8004 & 8003 CONSTITUTION PLACE N.E. 11-⁰⁷~~06~~79

December 13, 1979

Re: 8004-8008 Constitution Place N. E.

Site Plan

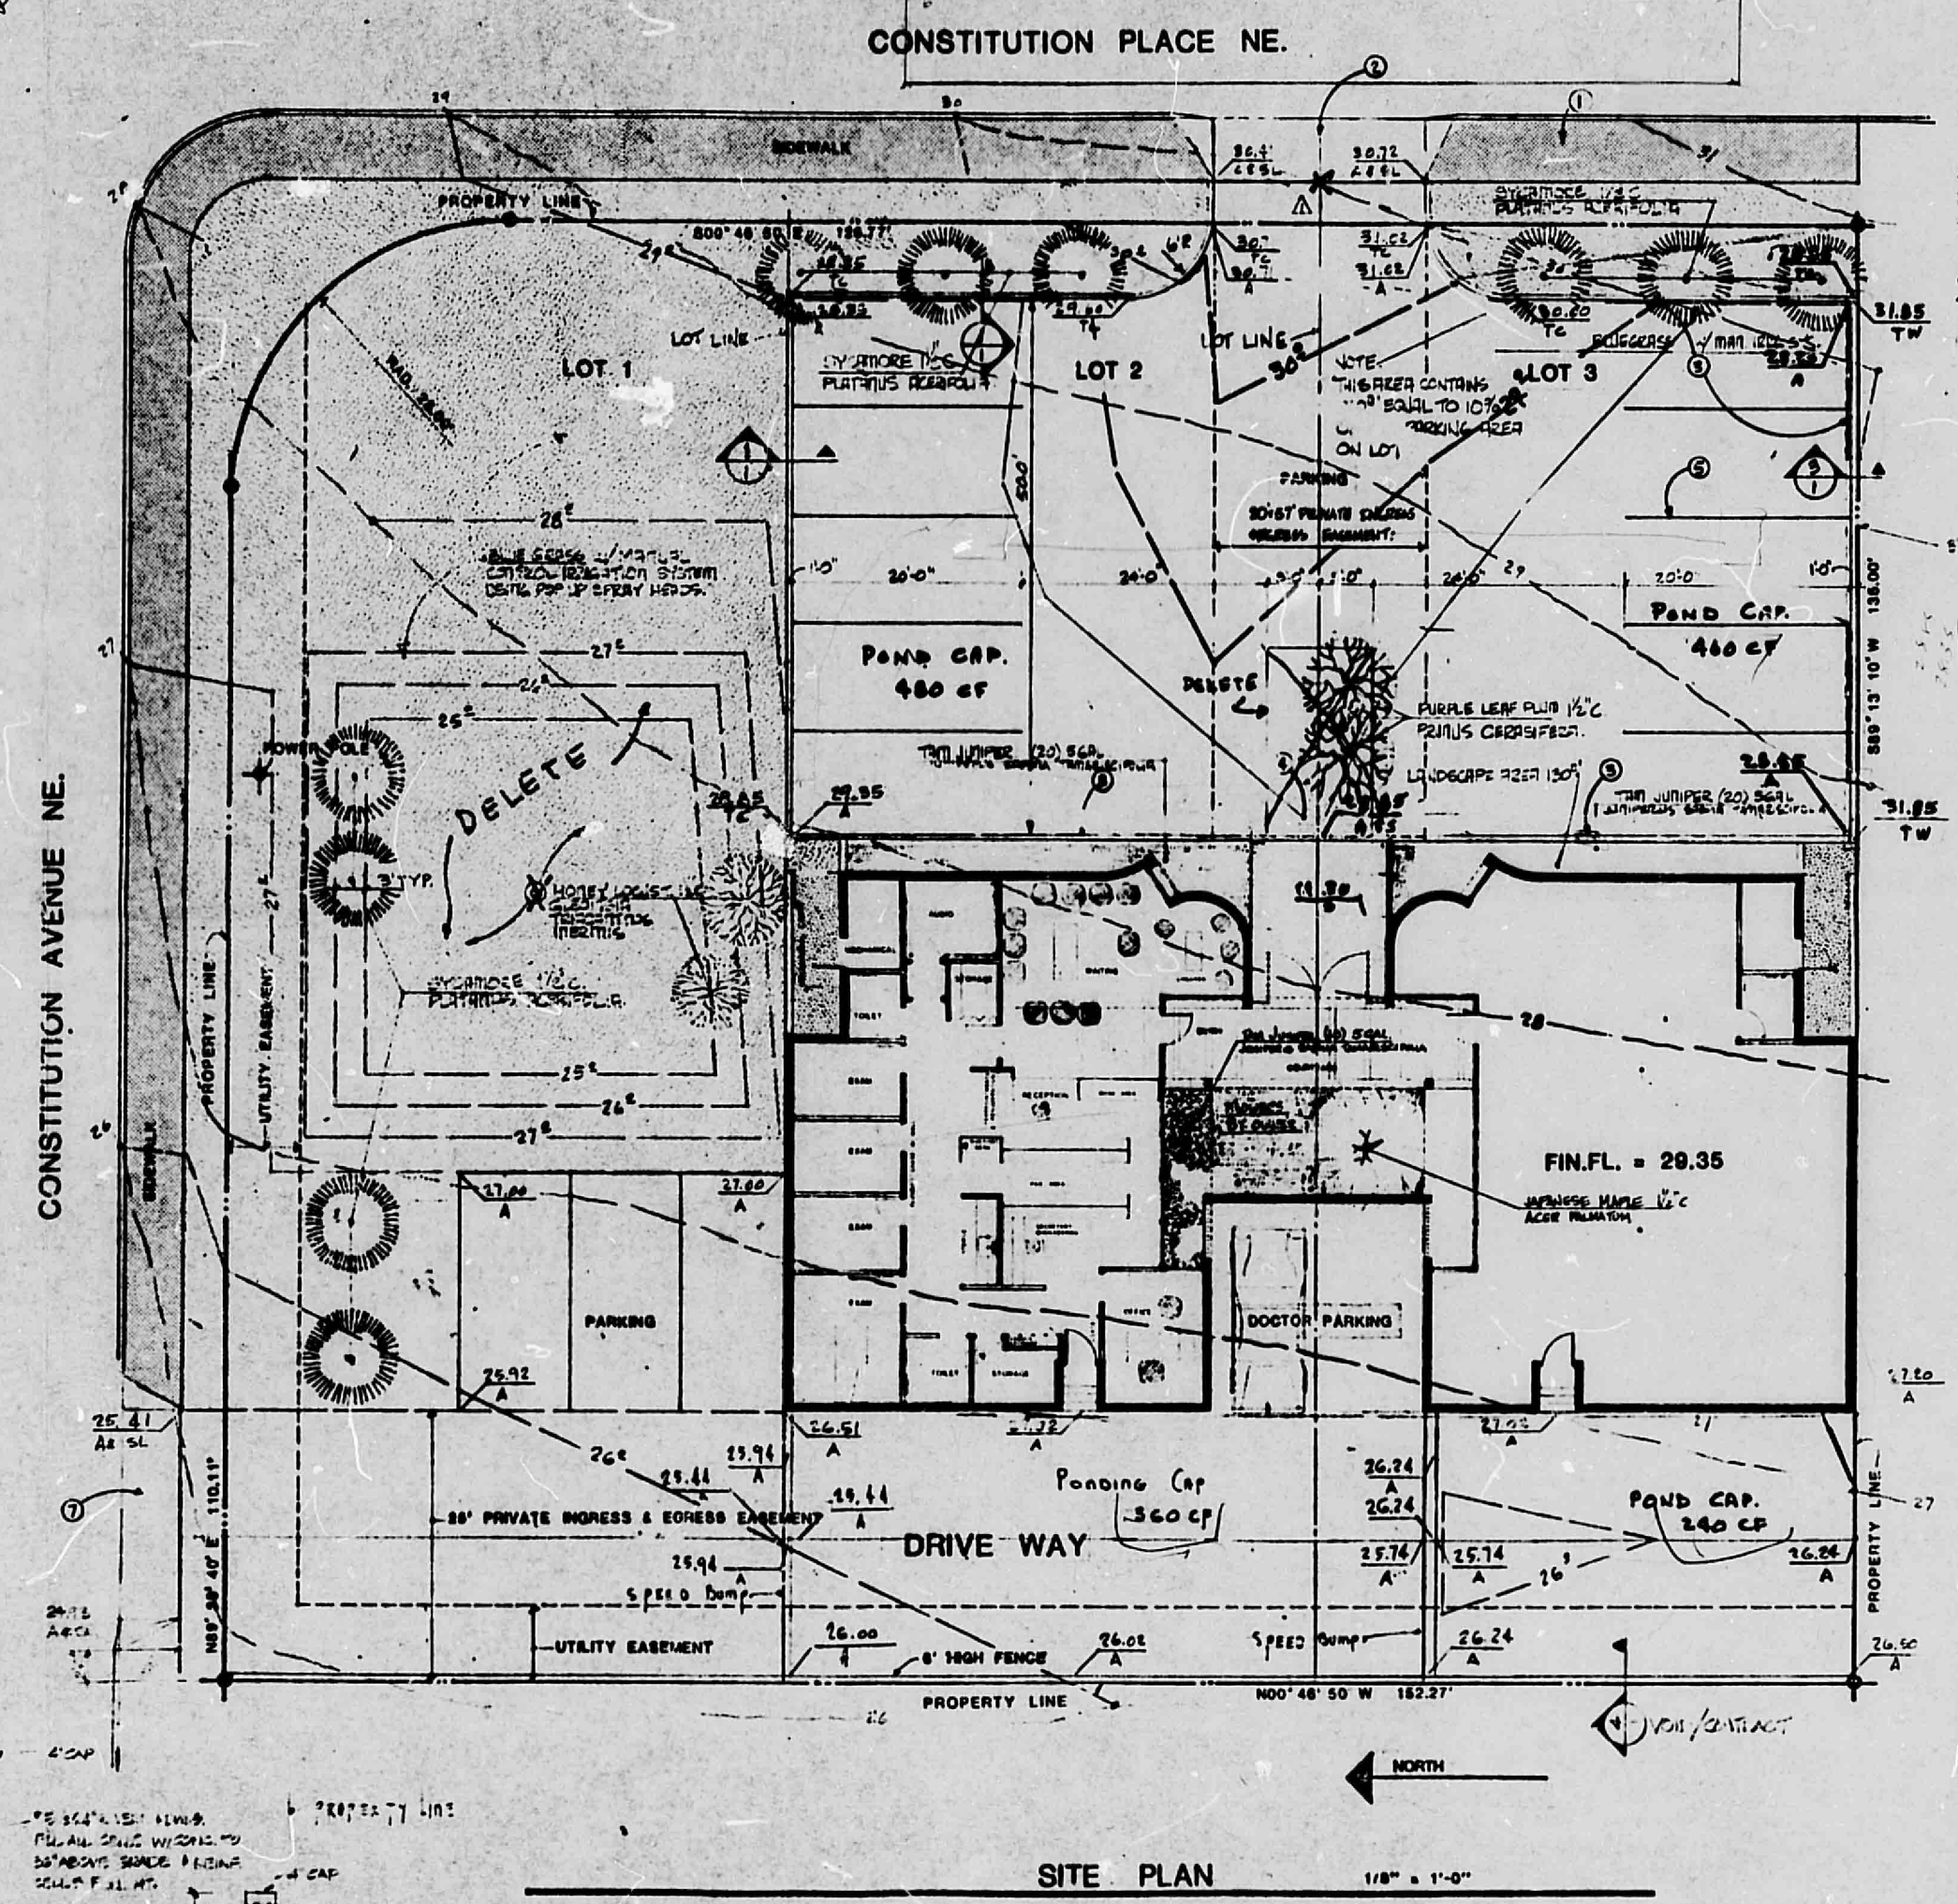
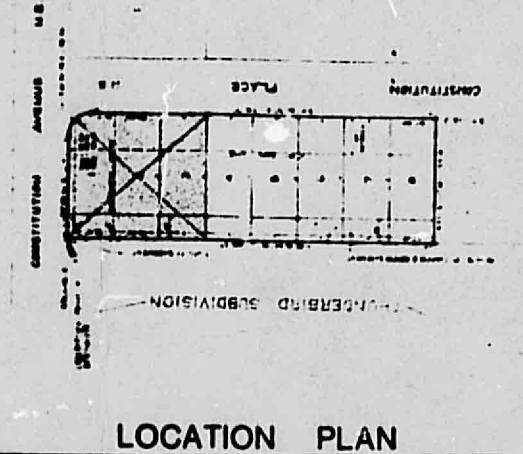
In light of the revised grading plan submitted to me by Mr. Tobias of Flatow, Moore, Bryan & Associates, and which was approved by the City, I requested my inspectors to survey the above referenced site to verify compliance with said plans. The survey could only verify approximately one-third of the required ponding volume.

I have been informed that the grading for the above referenced lot was done contrary to the grading plan approved by the City. This action is in violation of City policies, and of the conditions under which approval was granted for construction.

I found that the two ponding areas in the front they are not bad at all because there is no ponding area because where the ponding area is supposed to be is covered by asphalt so the water is just going to drain in the parking lot all the time. Now in the end in the East side of the Bldg. a driveway is right in the middle of it with a cover of asphalt, so we also going to have water ponding in there because there won't be no way for the water to drain.

As I informed you earlier, compliance with the approved grading plan is mandatory. If compliance with the approved plan is not feasible, we will accept a revised grading plan adhering to City drainage requirements.

If compliance with the approved grading plan is not feasible, submit a revised grading plan adhering to the City drainage requirements to my office for review.
